LOCAL CENTRE PLANNING APPLICATION CONSULTATION COMMENTS SUMMARY 15/00760/F

Statutory Consultee	Comment	Consultant Team Response
Bioregional	<p>Building footprint/GIA</p> <ol style="list-style-type: none"> 1. P6 Table 3.1 provides the proposed non-residential uses in the local centre. The total GIA of these uses adds up to 3,066 m², 350 more than the 2,716 m² stated. The Energy Centre GIA appears to have been omitted from the total. 2. No assumptions are provided for translating the total floor area of building types to GIA in table 3.1. Different land uses have different ratios of GIA to Total Area, presumably due to outdoor space and multi-storey buildings. It would be helpful if the assumptions were stated. 	<p>Response issued to CDC in w/c 13 July 2015.</p>

Rendered Landscape Masterplan

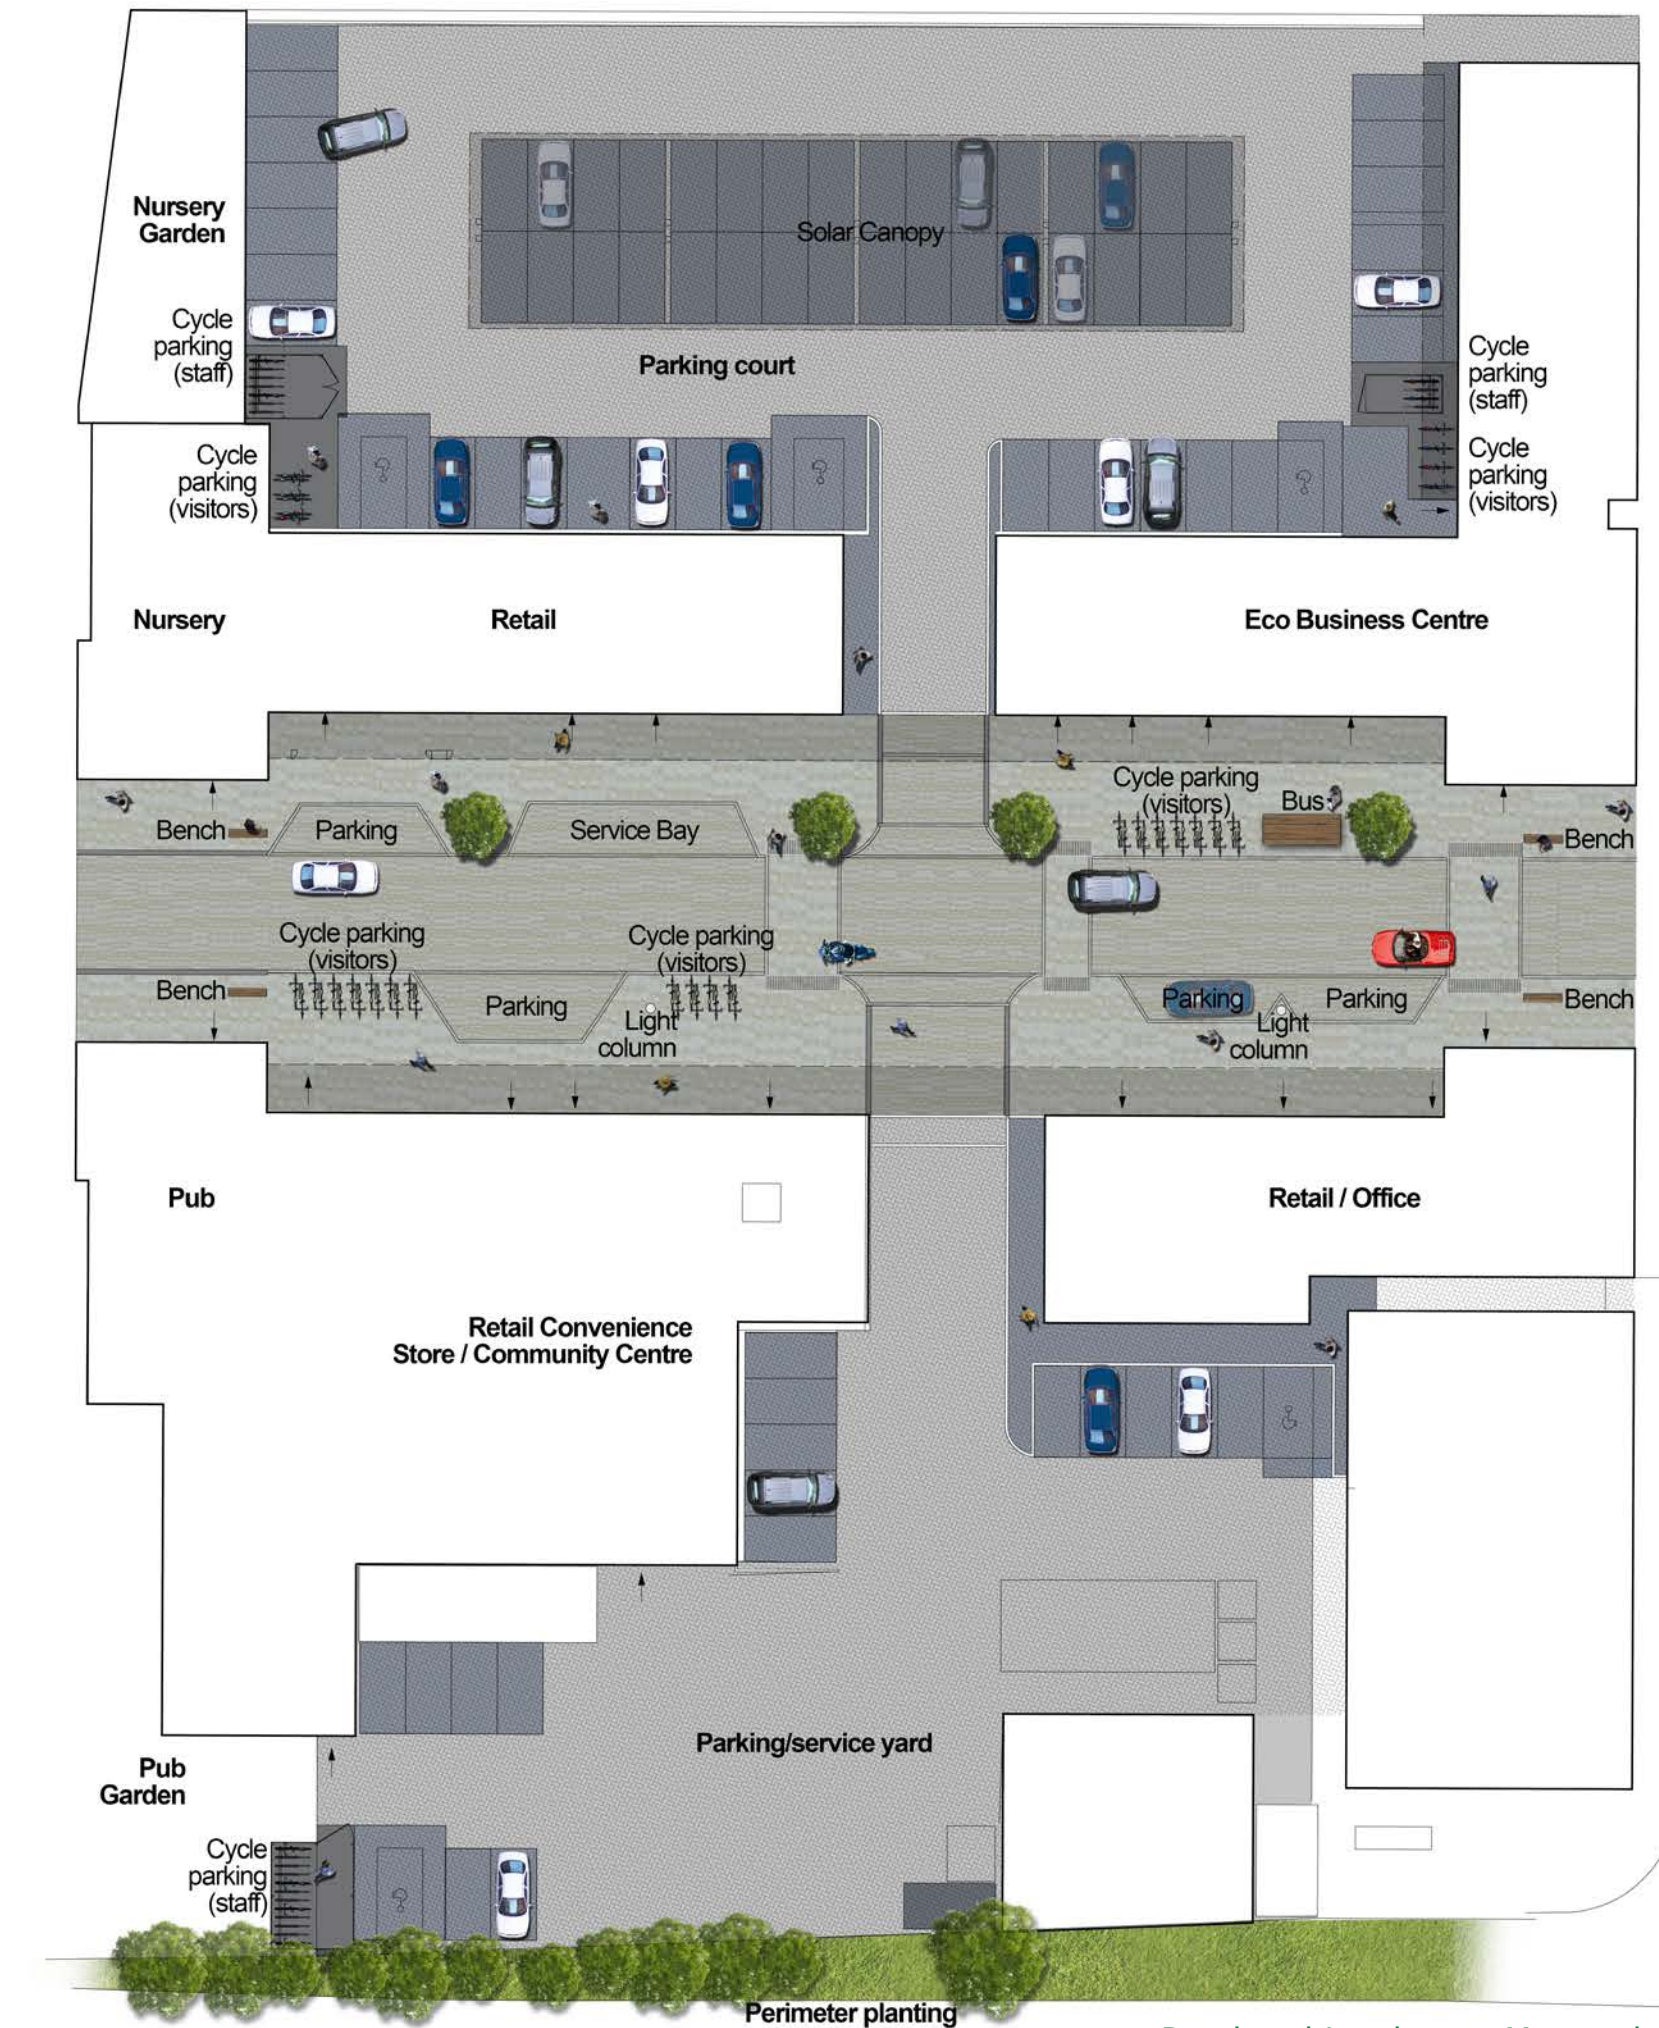
<p>Cherwell District Council</p>	<p>Landscaping</p> <p>Comments are made in relation to the species of trees proposed within the street scene (the Carpinus Betulus – Frans Fontaine) that are the same as the street trees through the rest of the local centre and suggestions are made as to an alternative to provide a complimentary variation, to encourage species diversity and to improve bio-security on-site. Suggested alternatives are Liquidamber styraciflua ‘Worplesdon’, Gleditsia triacanthos ‘sykline’ or Ginkgo biloba ‘Lakeview’. Can we consider alternatives and update landscape plans or justify current proposals and why other options have been discounted.</p> <p>Comments relating to tree pits should be noted. CDC proposes that these are addressed by way of a planning condition unless we can provide detail now.</p> <p>Can the retained hedgerow buffer to the south arcade be drawn accurately as per the tree and hedgerow survey? It is considered that a close mown grass edge close to the kerb would be tidier and define a clear separation between the trees and kerb. Proposed trees within this</p>	<p>Landscaping: We propose that hard and soft landscaping and tree pits are dealt with by way of planning conditions.</p> <p>Cycling: Secure cycle compounds are generally of this type of appearance, as the use of metal mesh means they can be secure whilst transparent enough to afford good visual surveillance/not feel intimidating to enter.</p>

<p>hedgerow require revision. The <i>Fagus sylvatica</i> (Beech) are too large for the allocated space and should be replaced within the smaller <i>Carpinus betulus</i> (Native Hornbeam). It is also considered that the <i>Alnus glutinosa</i> (Native Alder) is not usually a hedgerow tree and should be replaced with <i>Sorbus aucuparia</i> (Mountain Ash).</p> <p>Concerns about the timber benches which look uncomfortable.</p> <p>The tiered secure cycle compounds are not attractive and should be submitted for something more sympathetic.</p>	
<p>Cherwell District Council</p>	<p>Ecology</p> <p>The Council queries the number of habitat boxes/ swift bricks proposed in the Landscape and Green Infrastructure Strategy (and their exact locations) which are needed and how this fits in to the overall proposal for the site. CDC recalls earlier discussions where a 'final' plan was drawn up which removed habitat boxes from the local centre and redistributed them elsewhere in the Exemplar. Has this changed or are these additional boxes?</p>	<p>In the final plan for the wider scheme boxes that were to be located on the local centre were relocated. The boxes that are now shown in this application are additional boxes to ensure that this element of the scheme when considered in isolation delivers a net gain in biodiversity.</p>

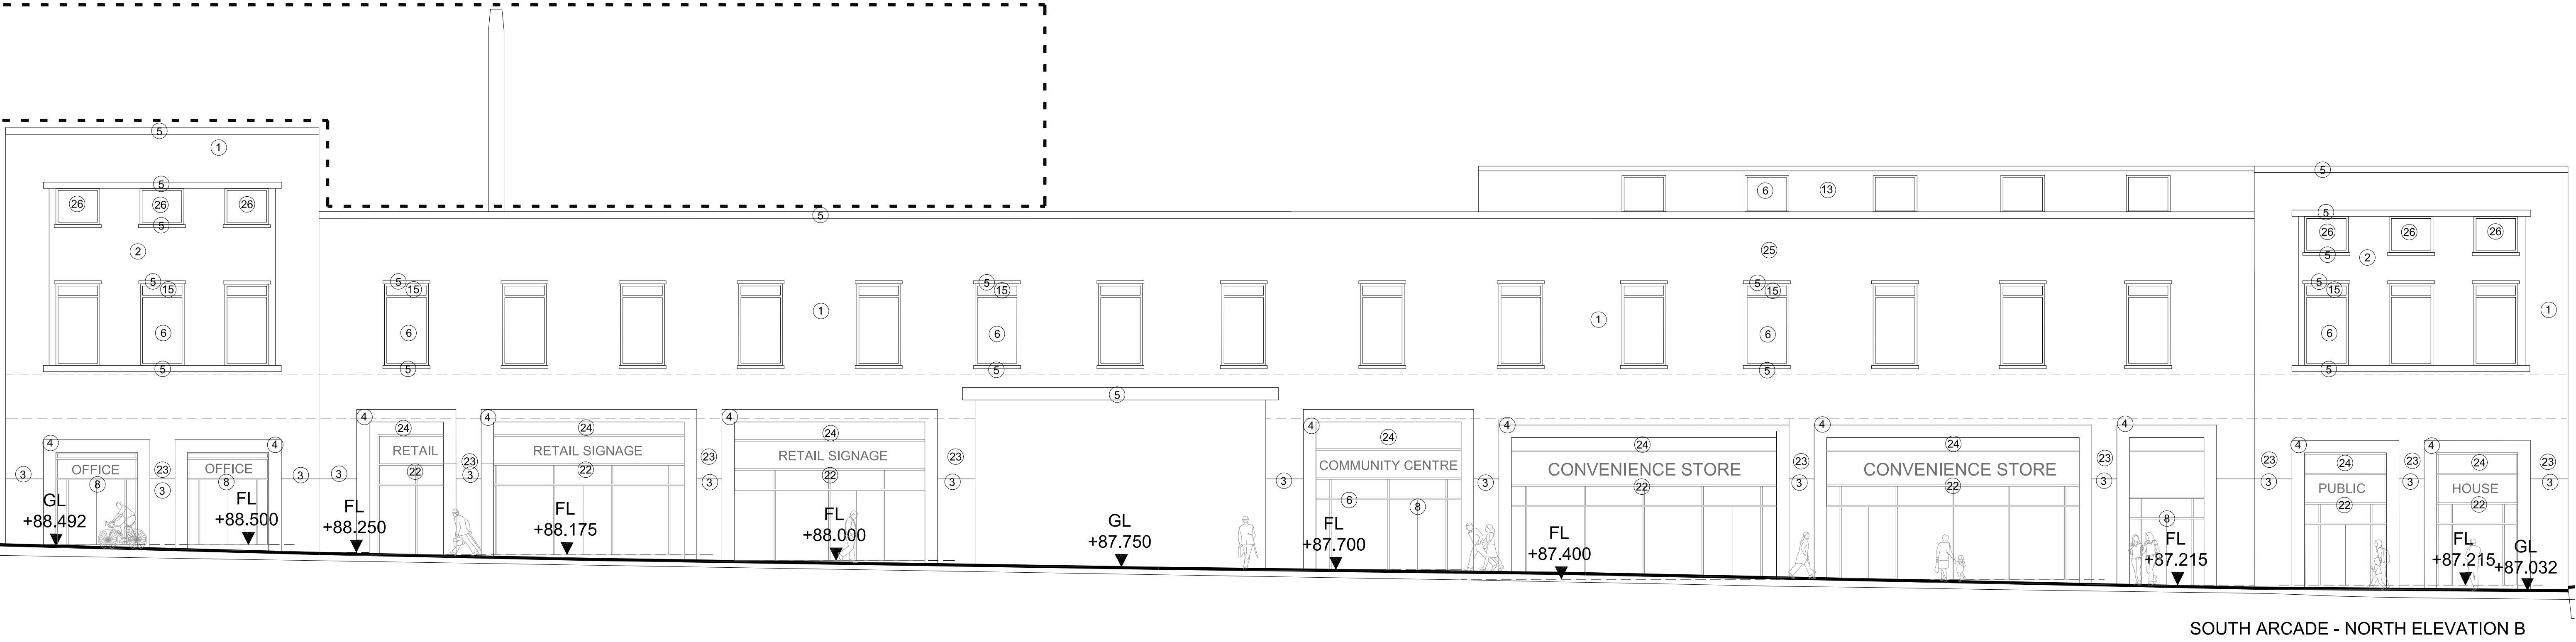
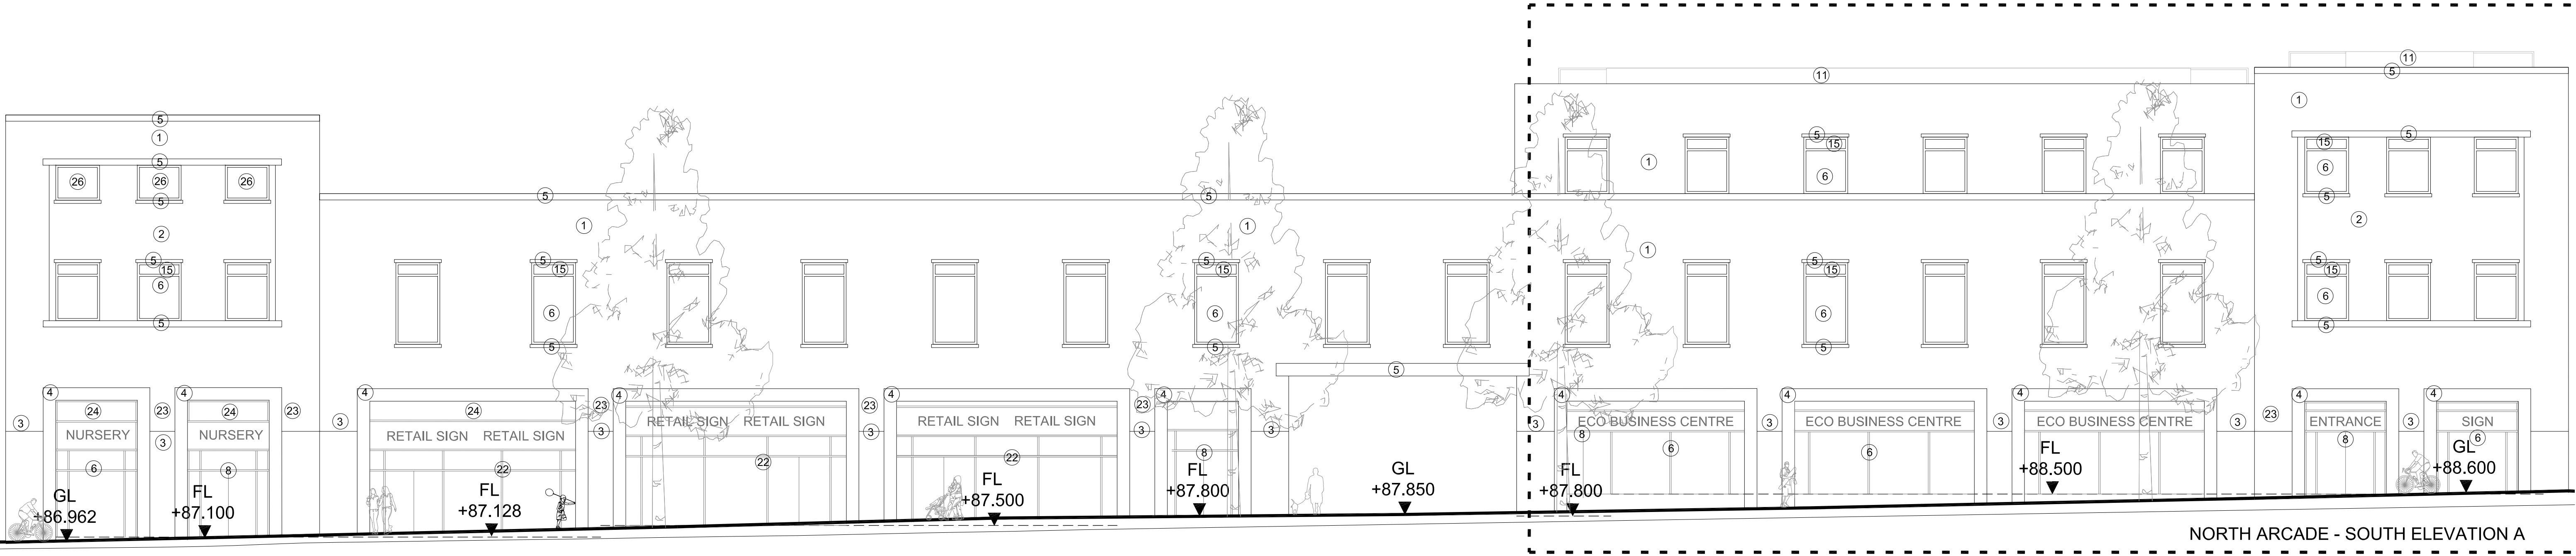
<p>How have over heating and day lighting been considered in this proposal?</p>	
<p>Cherwell District Council</p>	<p>Design</p> <p>CDC is not convinced that the pitched roof over the community centre works particularly well in design terms due to the contrast between this and the flat roof (with parapet) that is proposed for the rest of the local centre buildings. This introduces a more traditional arrangement that I feel will appear awkward taking into account the design of the rest of the local centre as a whole. I consider that it should follow the overall design concept that is being proposed and in these terms, the roof line would be more appropriate to follow the proposed across the rest of the proposed building. The Council's Community Development Officer has no objection in principle to this, however, would be interested in the material to be used from a future maintenance perspective.</p> <p>The current design for the southern arcade does not appear to work so well in design terms as the northern arcade does not appear to work so well in design terms as the northern arcade. CDC thinks that the reason could be the step in the ridge line where</p>	<p>We suggest that sloping roof should be retained and not changed to flat roof with parapet as suggested by CDC. We think the sloping roof contributes quality to external design as the points 1.1 to 1.3 and contributes quality to internal design as point 1.4.</p> <p>The sloping roof provides a step in eaves which follows the original Farrell elevation design concept to reflect the sloping site. The step in eaves is a carefully considered design and complements the step in height of ground floor openings on south arcade.</p> <p>The step in eaves is a good way to create variety in elevations whilst allowing the upper floor to be level with windows to be a similar scale to provide flexibility.</p> <p>The sloping roof allows a higher ceiling and north light into the interior of the community hall. This provides an opportunity for a quality of internal space which would not be achieved with a flat roof.</p> <p>The materials of the community hall are stated as:</p> <ul style="list-style-type: none"> i) slate on north side which is more steeply sloped and includes velux type rooflights ii) metal finish on south less steep and includes PV solar panels. <p>We suggest keep to brick design and we will provide additional options for contrast in colour and details (which could be conditioned) rather than add timber which at high level has durability and maintenance issues.</p>

<p>the community centre pitched roof is proposed. If the pitched roof were removed, and the parapet line raised to be the same level as the parapet line over the B1 office space, then CDC thinks that this would overcome concerns. Whilst the building would not be broken up by a step, the proportions around the windows would be better and would improve the visual effect. The downpipes that are indicated should then be removed.</p> <p>CDC is concerned about the brick contrast vent opening features at the bookend areas of the building, as well as the textured brick work and the visual impact of these as currently proposed. CDC would like to minimise the material palette and draw to a greater degree on the materials used within the housing scheme. CDC suggests the introduction of timber on the local centre in place of the contrast and textured brickwork or alternatively a different form of contrast brick. CDC suggests a small study of options for these features, and would be happy to comment.</p>
